COUNTY COUNCIL'S RESPONSE TO CONSULTATION ON THE FOLLOWING DEVELOPMENT PROPOSAL

Application No: 16/00472/OUT-8

Proposal: Proposed residential redevelopment for approximately 200 units.

Lead Local Flood Authority

GRUNDON BANBURY
PROPOSED SURFACE WATER DRAINAGE STRATEGY

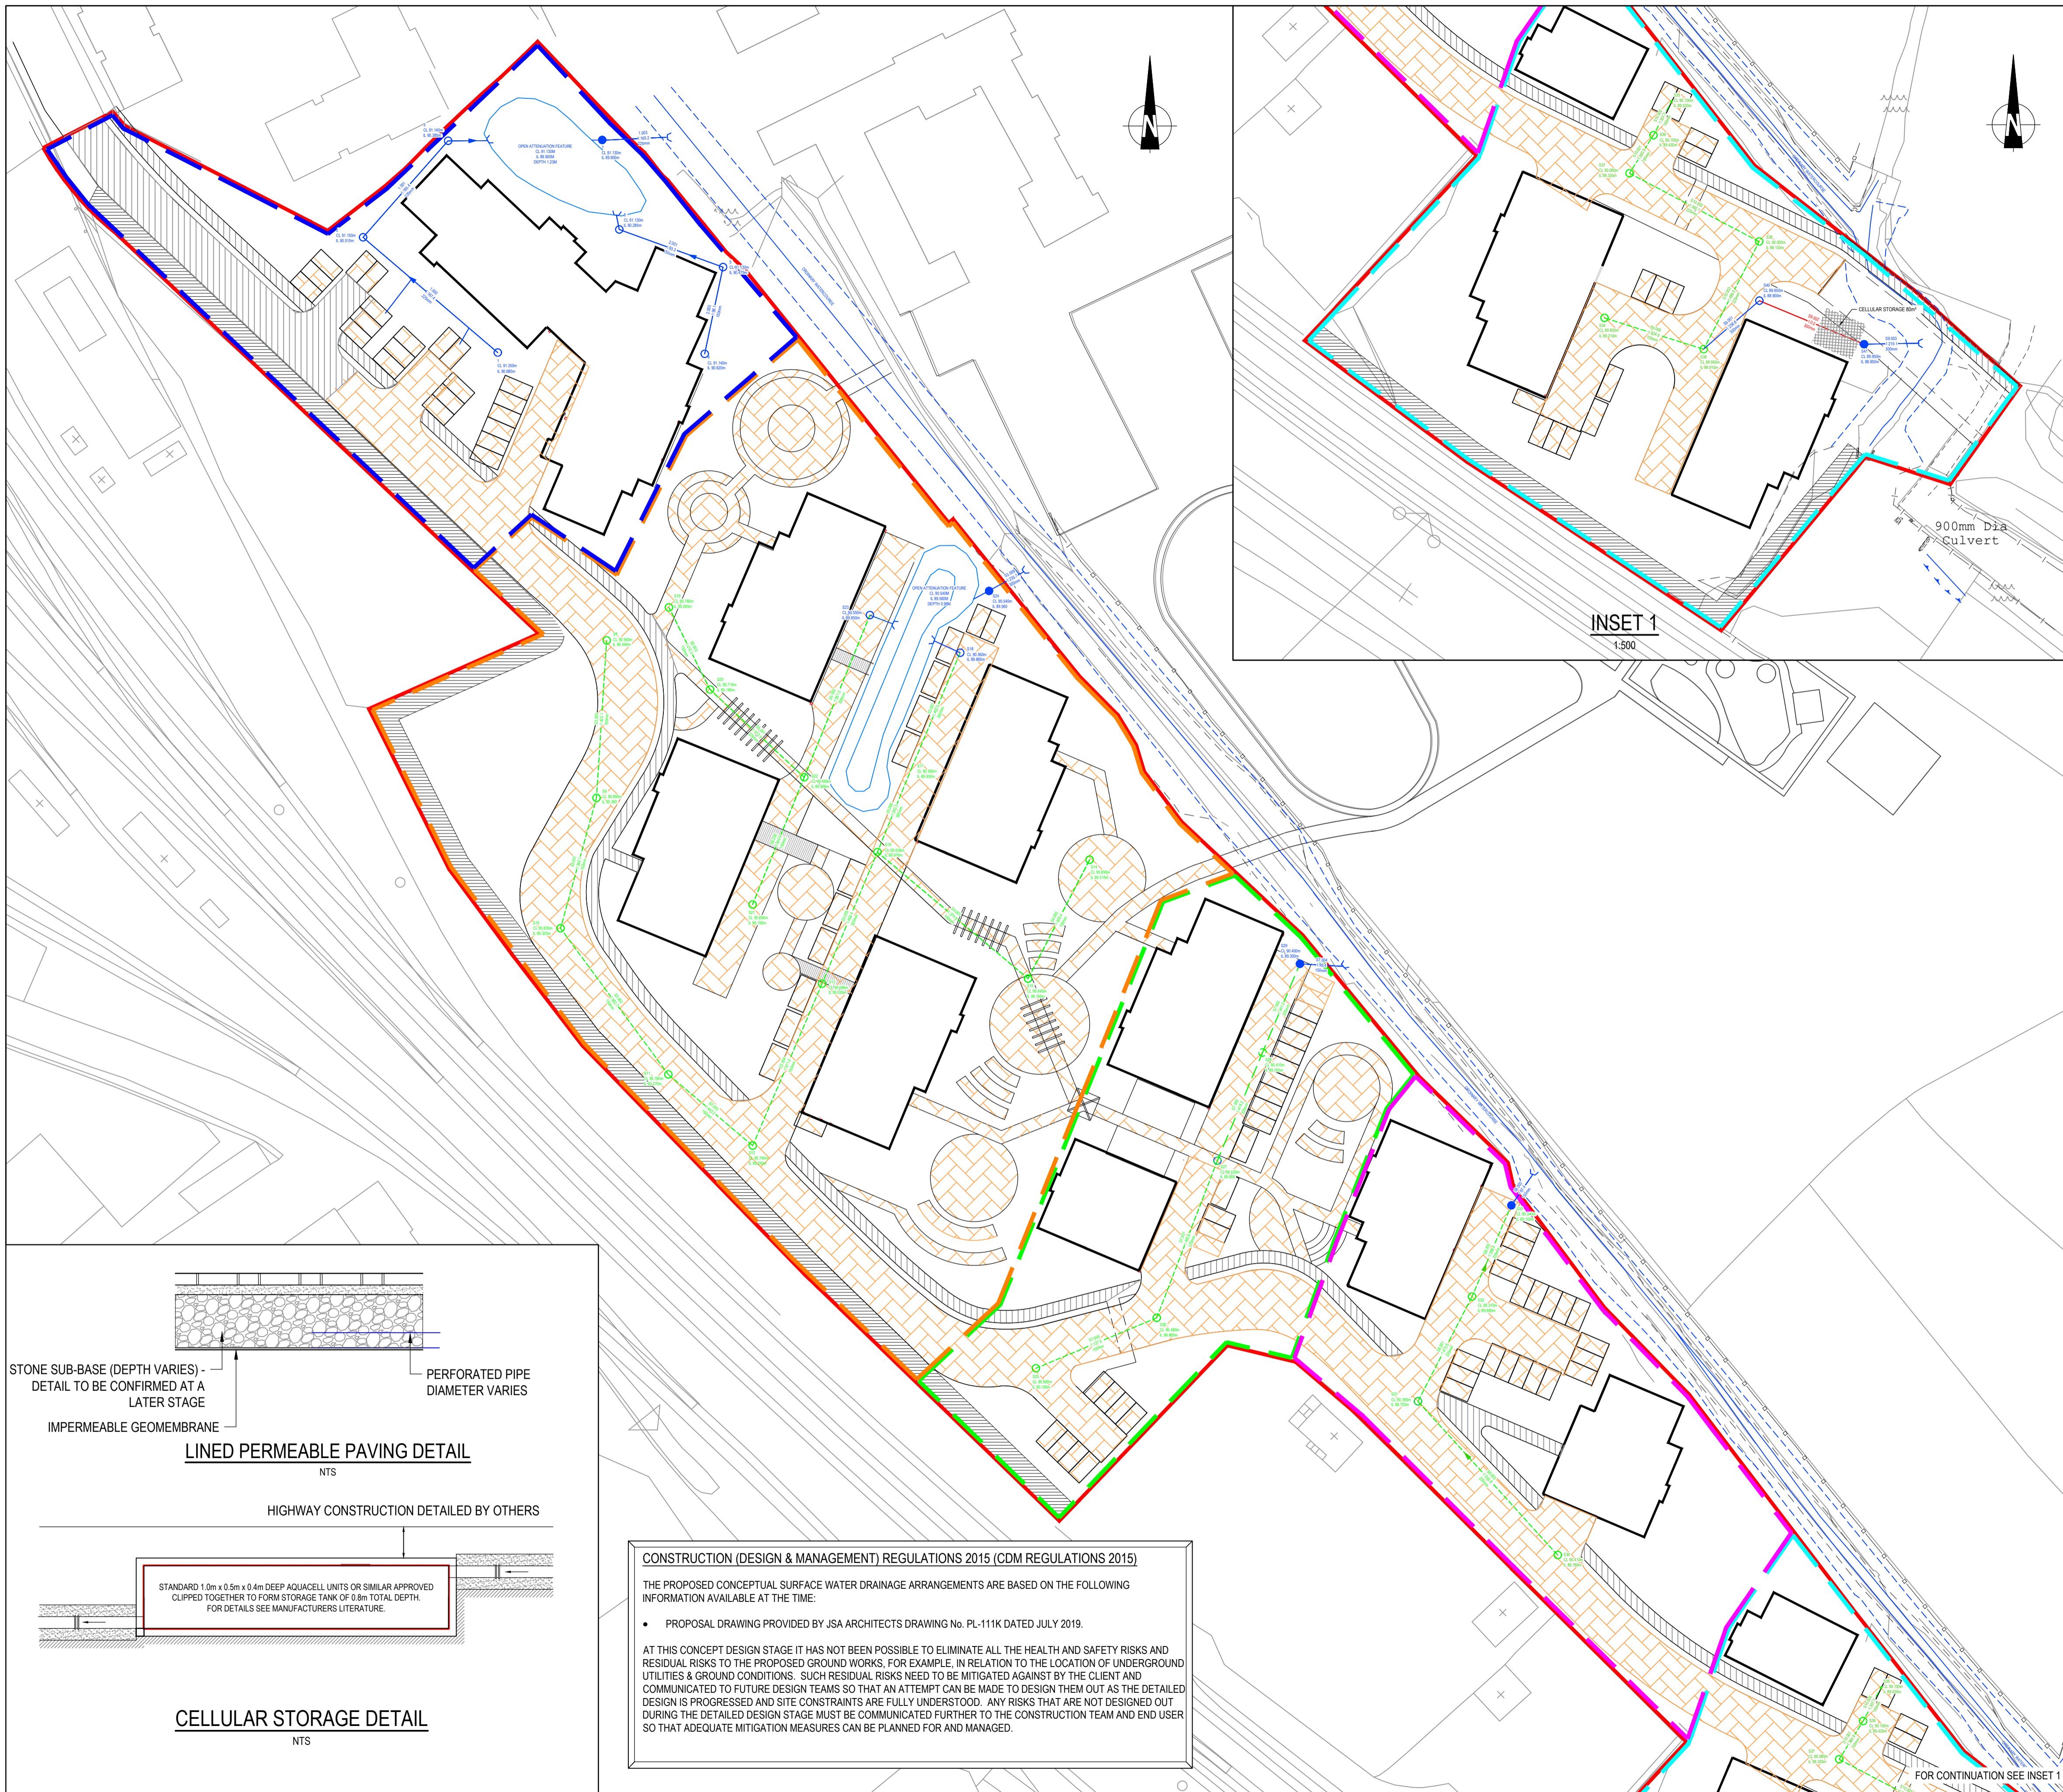
Whilst the technical note has been updated to reflect our current guidance, we are concerned that attenuation is proposed within flood zone 3 and proposed flood plain compensation areas on the latest surface water drainage drawing within the technical note dated 29/10/2020.

The drawing also does not coordinate with the latest layout plans and attenuation basins are shown in areas highlighted to be play areas.

It is unclear how the drainage will be safely integrated into the layout, without being significantly compromised by the fluvial flood plain.
